**Re: Sprinstone parking
Davenport st NW
Traffic Circulation Layout**
Engineer's/Architect's Stamp 09-18-2019 (C12D003B2)

Based upon the information provided in your submittal received 09-18-2019, the above referenced plan cannot be approved for Building Permit until the following comments are addressed:

SPRINGSTONE PARKING LOT AND GARAGE TRAFFIC CIRCULATION PLAN

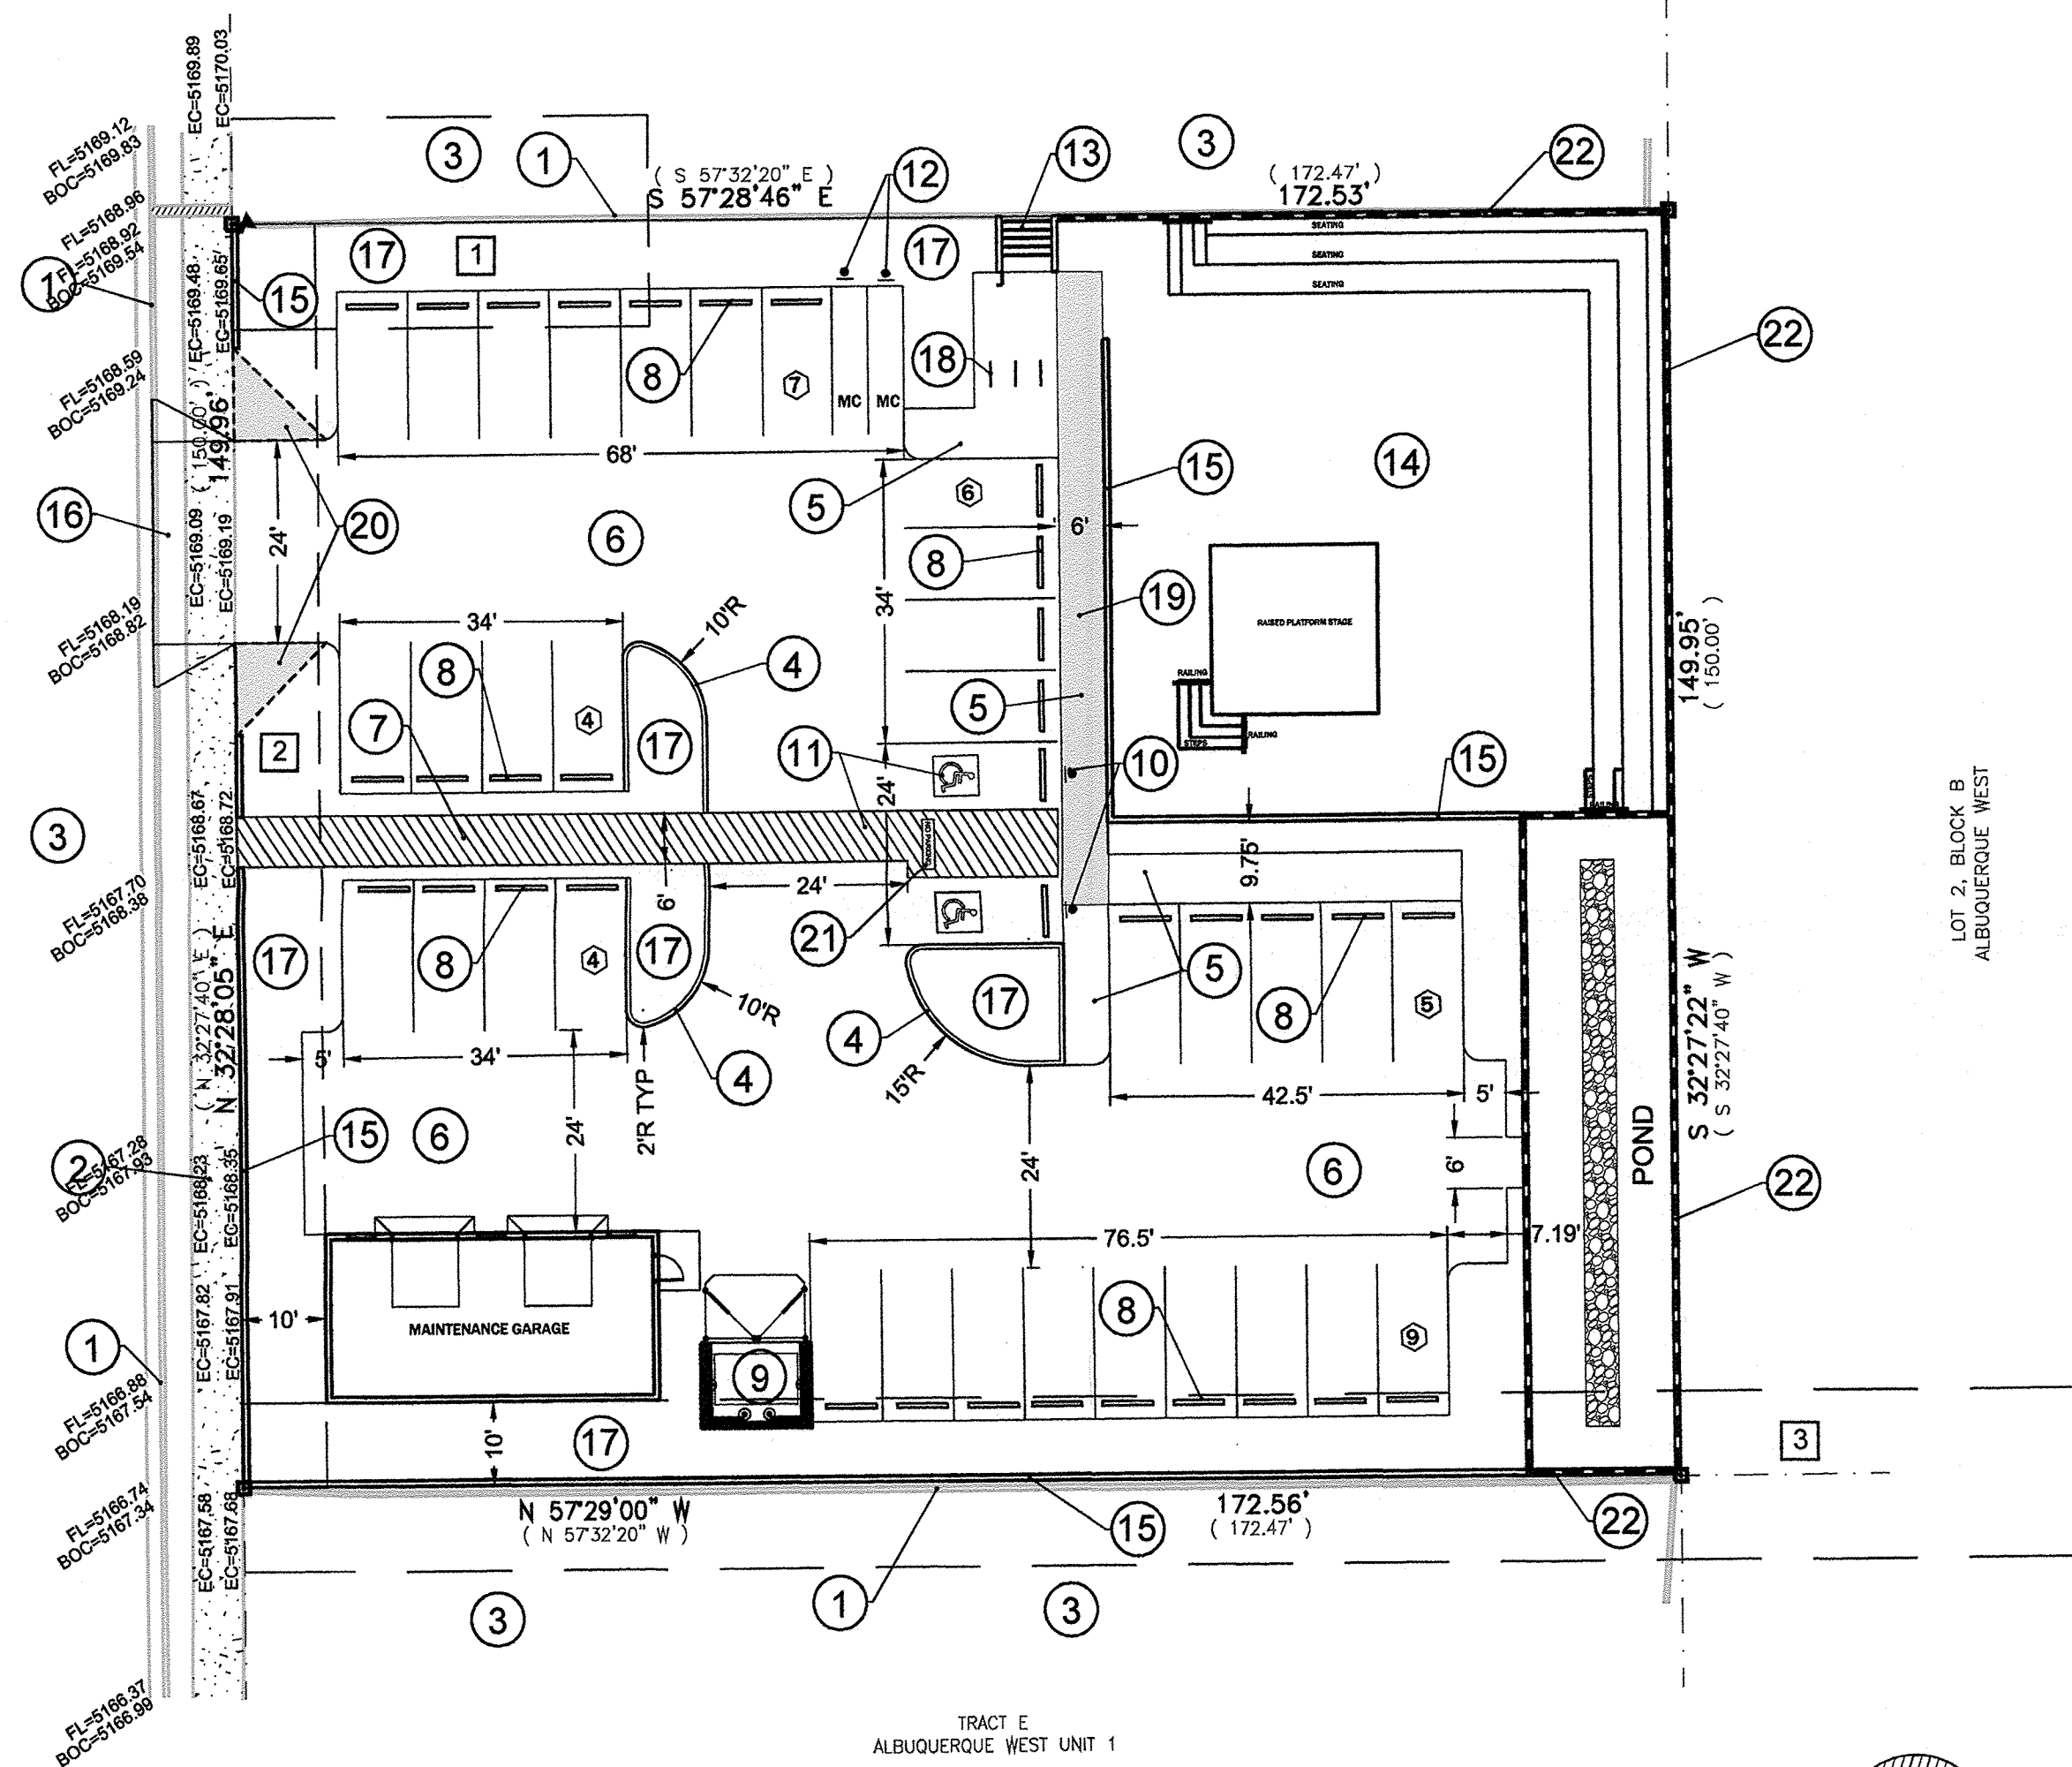
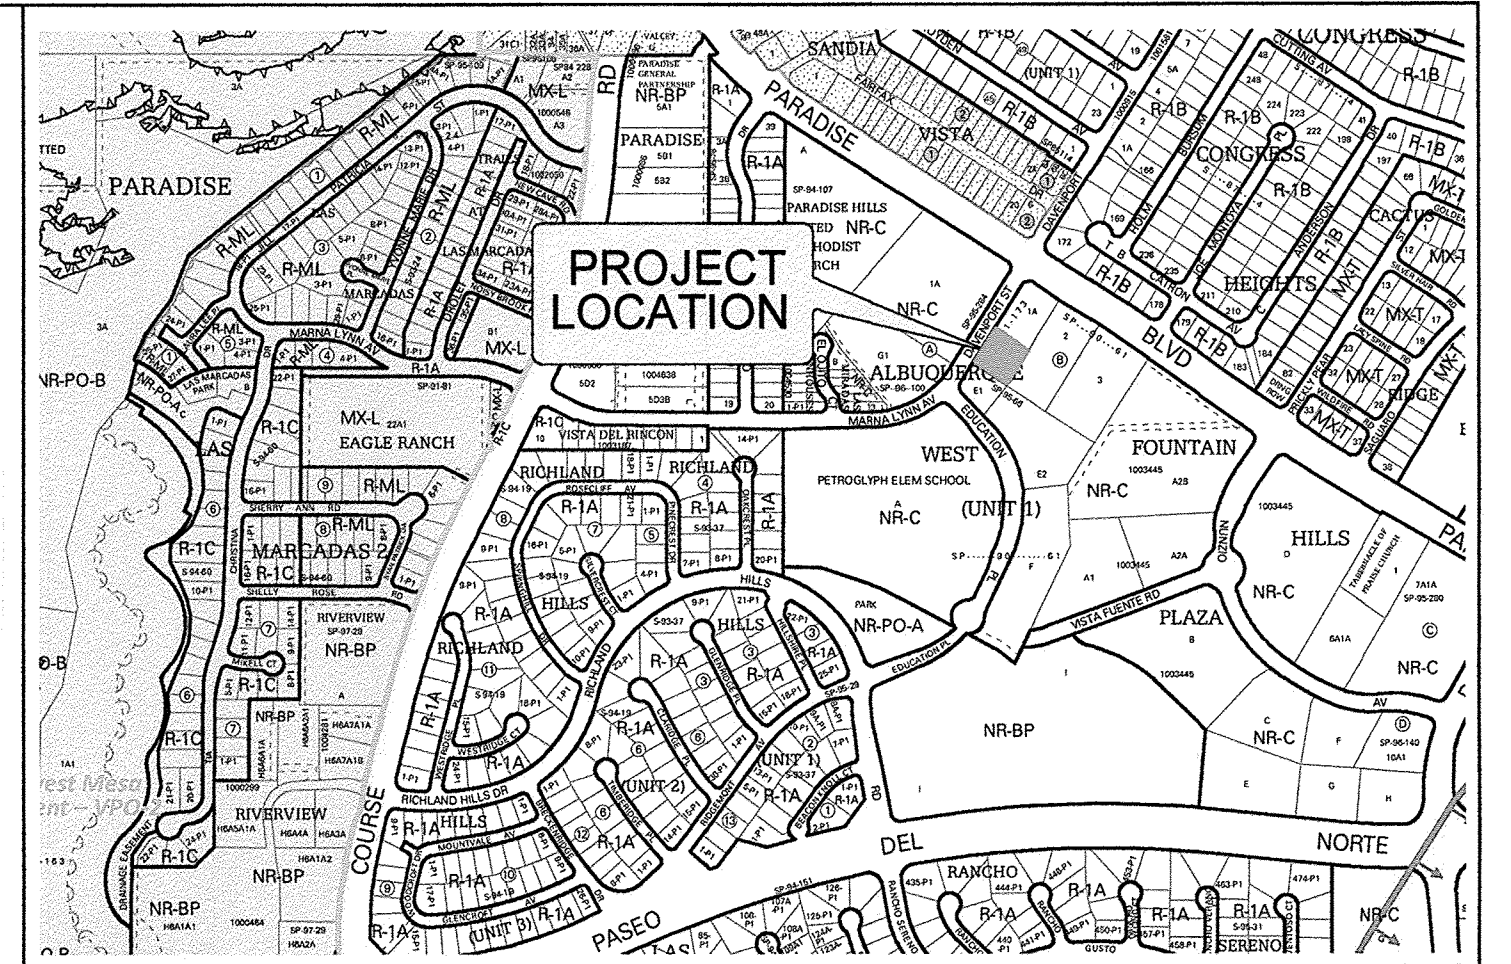
1. The ADA access aisles shall have the words **"NO PARKING"** in capital letters, each of which shall be at least one foot high and at least two inches wide, placed at the rear of the parking space so as to be close to where an adjacent vehicle's rear tire would be placed. (66-1-4.1.B NMSA 1978)

6. Per DPM, a 6 ft. wide ADA accessible pedestrian pathway is required from the ADA parking stall access aisles to the building entrances. Please clearly show this pathway and provide details.

7. Refuse vehicle maneuvering shall be contained on-site. The refuse vehicle shall not back into the public right of way.; **provide a copy of refuse approval.**
8. It is not apparent what type of pavement surface is being proposed. A hard driving surface will be required as part of this proposed project for parking area and drive aisles.
9. Show the clear sight triangle and add the following note to the plan:
"Landscaping and signage will not interfere with clear sight requirements. Therefore, signs, walls, trees, and shrubbery between 3 and 8 feet tall (as measured from the gutter pan) will not be acceptable in the clear sight triangle."

BIKE RACK - PLAN
NTS
F
C.3

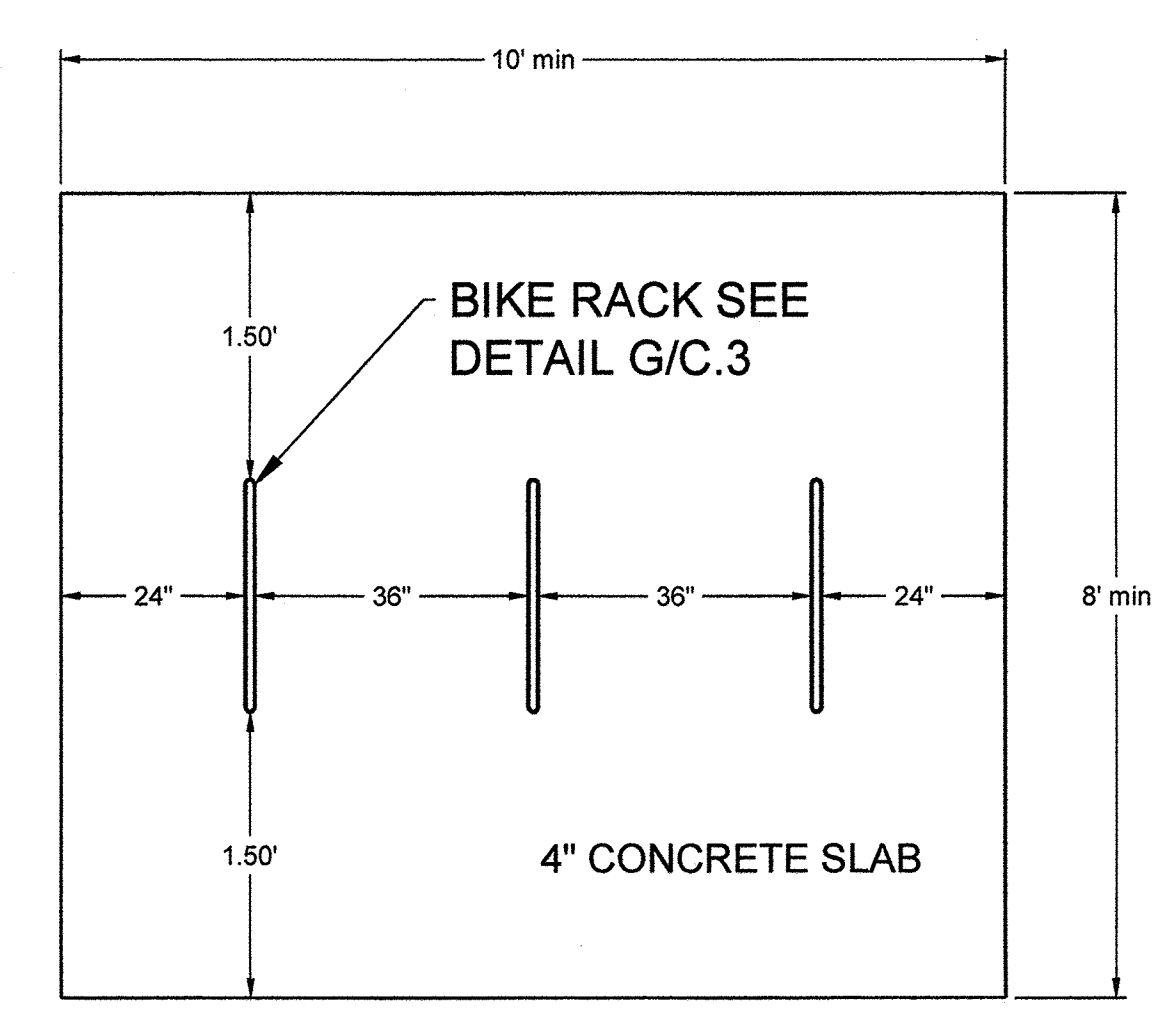
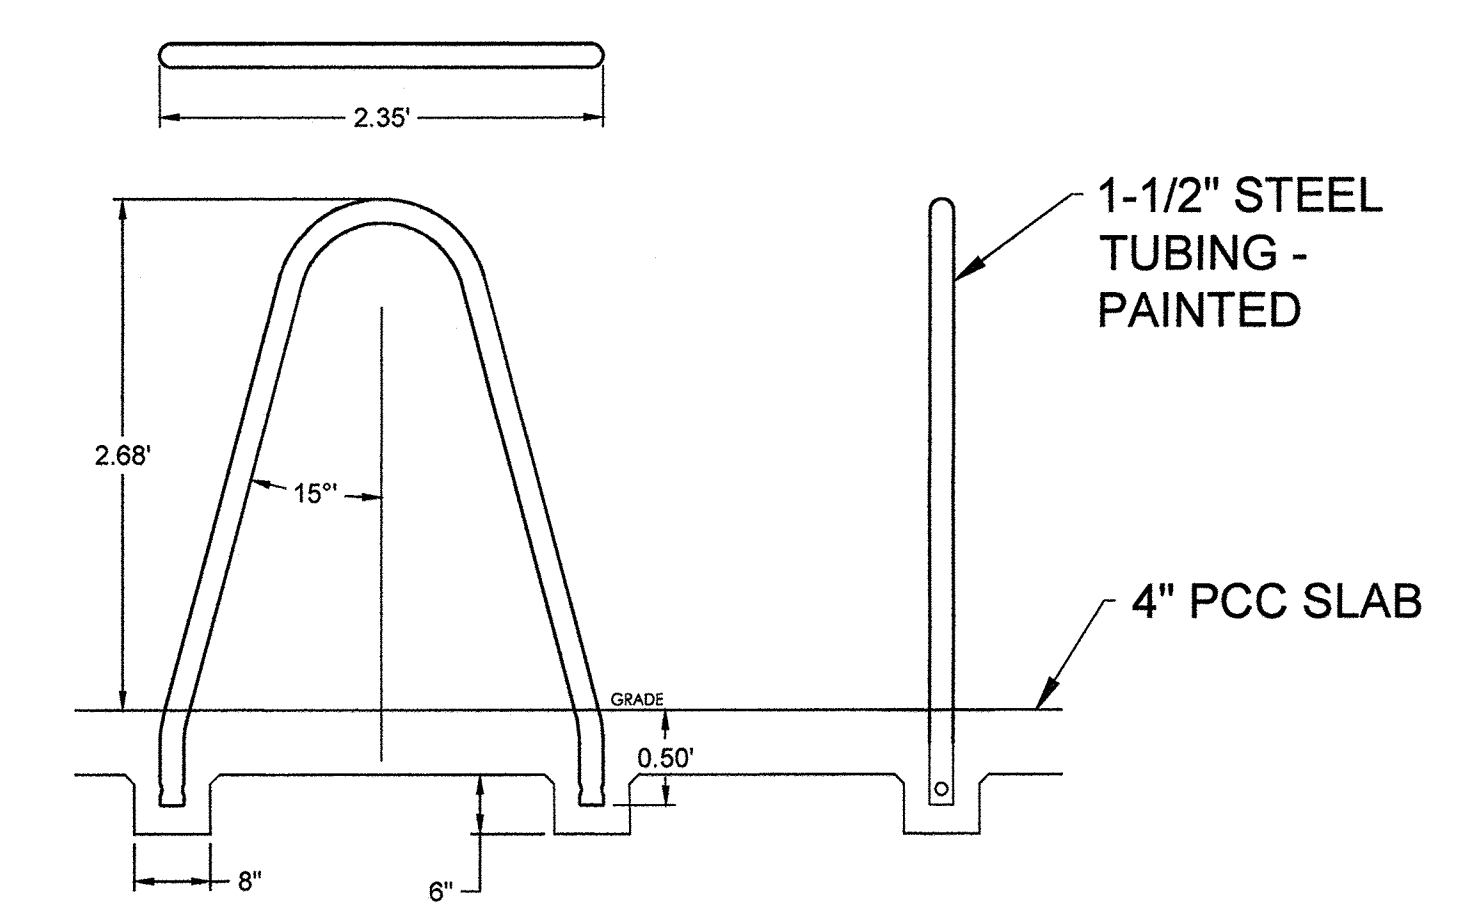
2. All bicycle racks shall be designed according to the following guidelines:
 - a. The rack shall be a minimum 30 inches tall and 18 inches wide.
 - b. The bicycle frame shall be supported horizontally at two or more places. Comb/toaster racks are not allowed.

- c. The rack shall be designed to support the bicycle in an upright position. See the IDO for additional information.
 - d. The rack allows varying bicycle frame sizes and styles to be attached.

- e. The user is not required to lift the bicycle onto the bicycle rack.
 - f. Each bicycle parking space is accessible without moving another bicycle.

3. Bicycle racks shall be sturdy and anchored to a concrete pad.
4. A 1-foot clear zone around the bicycle parking stall shall be provided.
5. Bicycle parking spaces shall be at least 6 feet long and 2 feet wide.
